Reference No: 2021/62/90350/W

Site Address: 153, West End, Netherthong, Holmfirth, HD9 3EJ

Description: Erection of single storey side extension to dwelling and extension to detached garage to form garden room (within a Conservation Area)

Officer Report

Drawing title
Proposed Elevations

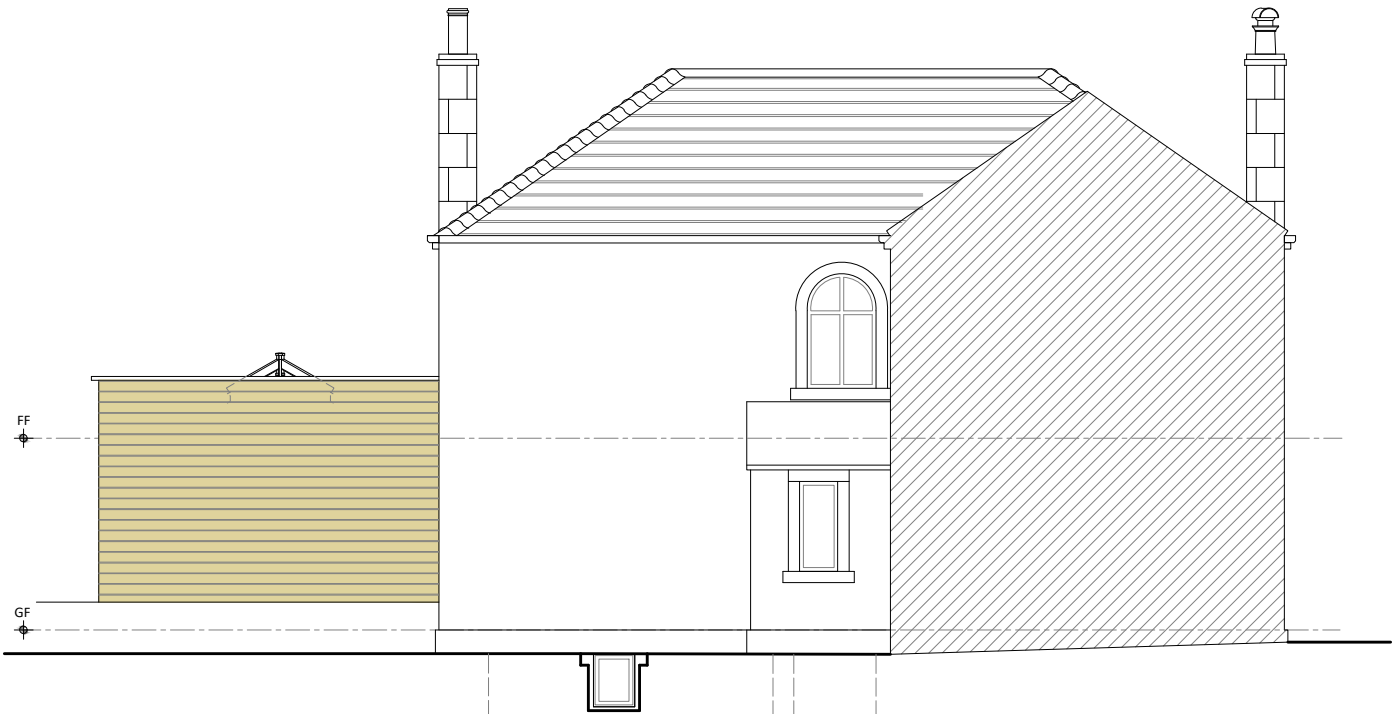
The one storey garage extension would project from the northeast/side elevation by 3.2mm and be 6.42m width while being constructed over changing ground levels. The roof would be lean-to and from the host building ground level would be 2.75m roof ridge height and eaves at 1.1m approximately. From the lower ground level, the roof ridge height would be 4m and 2.2m approximately. The extension would be lower than its garage host due to the ground level change. There would be windows and glazed doors facing northeast towards the Church and no other openings to the side elevations. It would serve as a garden room. The proposed materials of the garage extension are natural stone and artificial stone tiles to match the existing, uPVC windows and glazed timber door.

The one storey side extension would project forward of the primary elevation by 1.5m and its southeast elevation would be a width of 4.8m then extend 6.9m in depth to finish with the rear elevation of the extension measured at 4.5m. The rear elevation of the proposed extension would be stepped in 0.4m from the rear elevation of the host dwelling. This would serve a dining room to the fore and rear a study and wash room. The proposed materials of the house extension are natural stone to match the existing, a flat roof with parapet walls, a lantern roof light and timber framed windows.

The Conservation Officer requested detailed plans on the parapet and received them to assess that the proposal had sufficient regard for the Conservation Area's special character and quality. The proposal has been assessed by the Conservation Officer and is not considered to harm the character or significance of the conservation area or the setting of the listed buildings. Therefore no public benefits are required to mitigate the scheme. Regarding the proposal for the host dwelling's side extension, the front elevation would be forward of the principal elevation and normally this would not be regarded as subservient. The site has some limitations with the extension unable to be built on the boundary in order to avoid Party Wall issues which restricts its layout and so is set back from the rear boundary. On balance, weighing up the site restrictions with the limited height of the single storey extension, flat roof with parapet walls and use of matching materials would be considered to be sufficiently subservient to meet LP24. In addition, it is set some distance from the surrounding listed buildings and would be of no harm to the character of the Conservation Area.

The existing detached garage which in turn is located at the southern boundary of the site's substantial garden and is proposed to have a modest 3.2m extension projecting from the side elevation set lower than the garage minimising its impact and scale, the proposed materials match the existing and would be considered a subservient extension in scale.

3. The external roofing materials of the garage extension hereby approved shall in all respects match those used in the construction of the existing building.

4. The external roofing parapet detail of the host dwelling's side extension hereby approved shall in all respects match those detailed in 'Proposed Parapet detail and sample photos. Drawing No: PL-05. Project no: 20-726. Dated: April 2021'.

5. The external walls of the hereby approved extensions shall be constructed of natural stone and laid in courses to match the existing.

Drawing title
Proposed Ground Floor
and Roof Plan

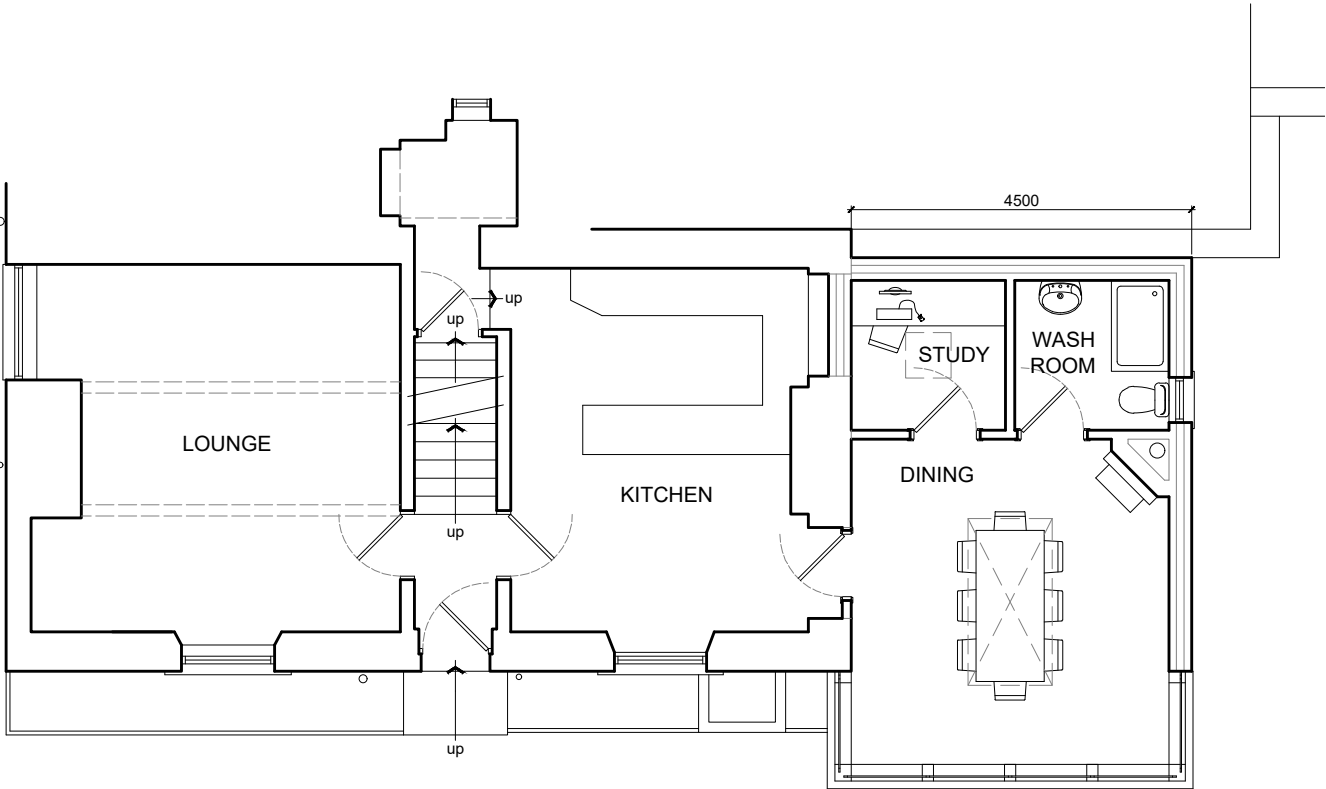
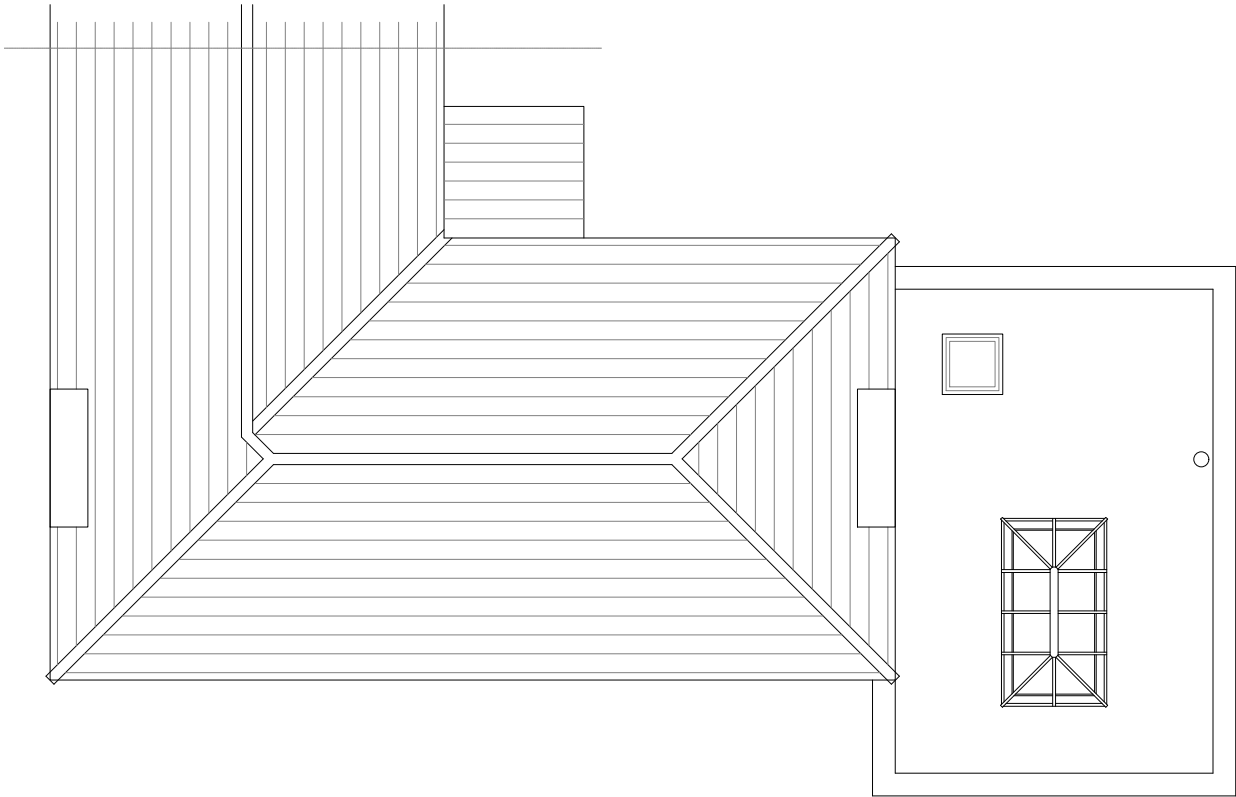
The case officer considered the application on review and sought to have more detail concerning the parapet after the Conservation and Design

Officer's response to consultation and clarification on the house extension placement.
